CITY OF ALBUQUERQUE

July 26, 2022

**RE: Apple Canyon Gourmet
1301 Cuesta Abajo Ct. NE
Temporary CO – Accepted
Traffic Circulation Layout Approval Date: 10/6/21
Architect Stamp Date (rev): 7/26/22
Transportation File: D16D002H**

PARKING CIRCULATION LAYOUT PLAN

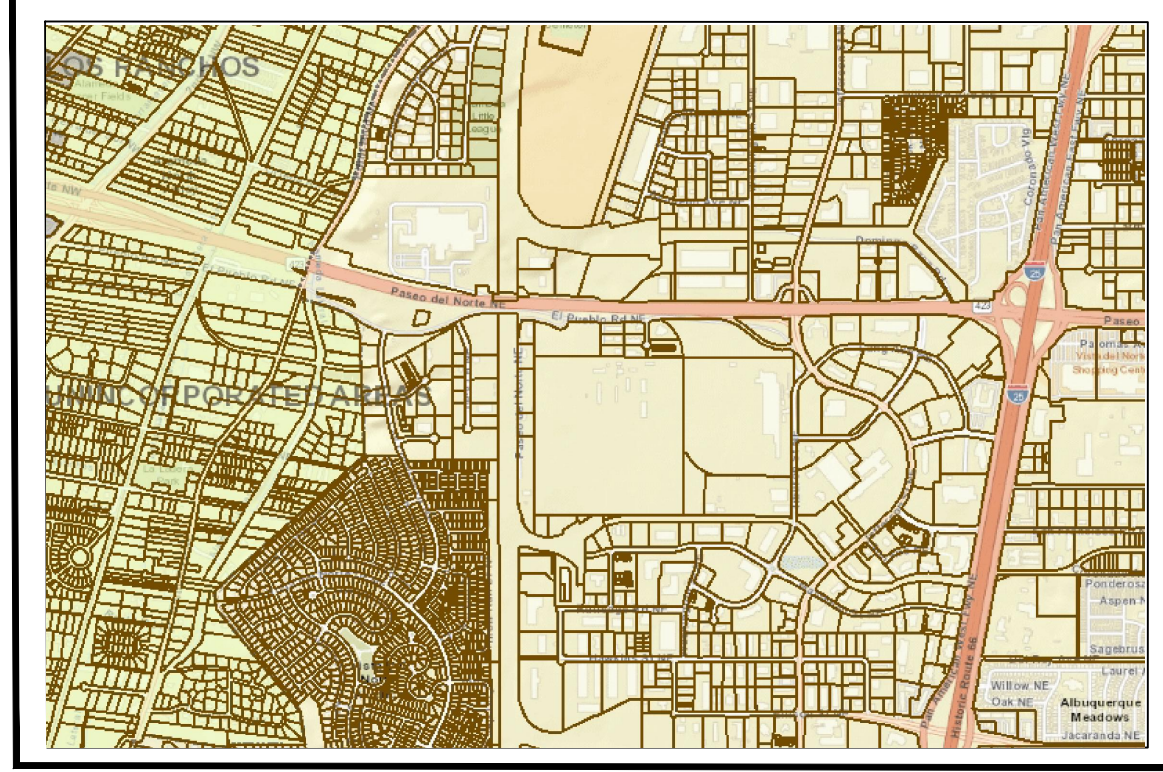
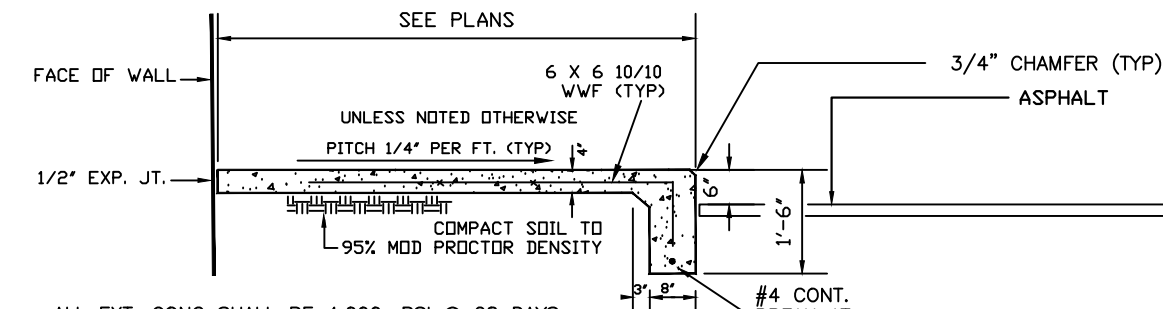
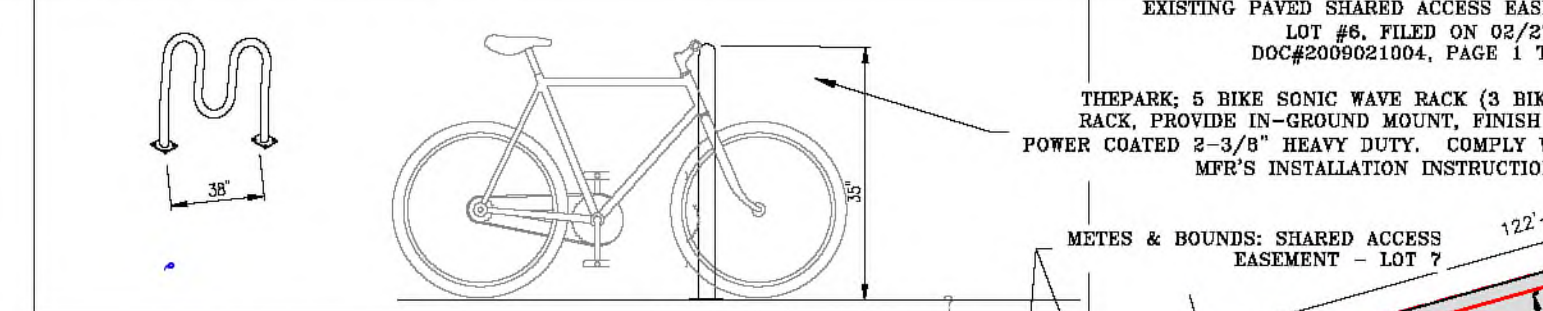
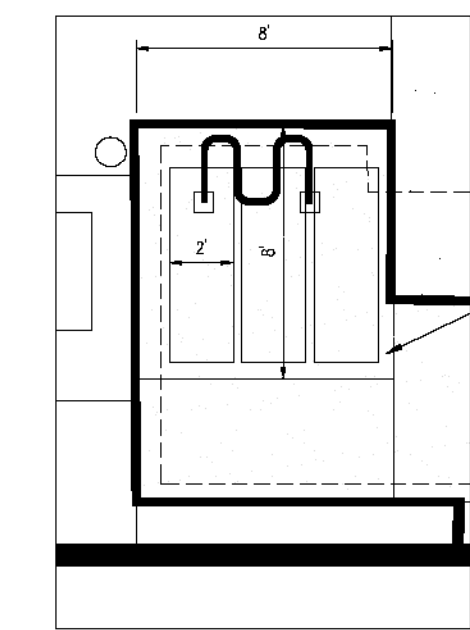
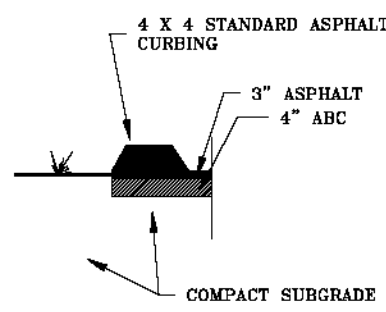
Prior to the issuance of a permanent Certificate of Occupancy, the following items (per your letter) must be addressed:

- Fire Lane paint striping.
- Parallel Parking space paint (please dimension parallel spaces and distance to perpendicular spaces on plan).
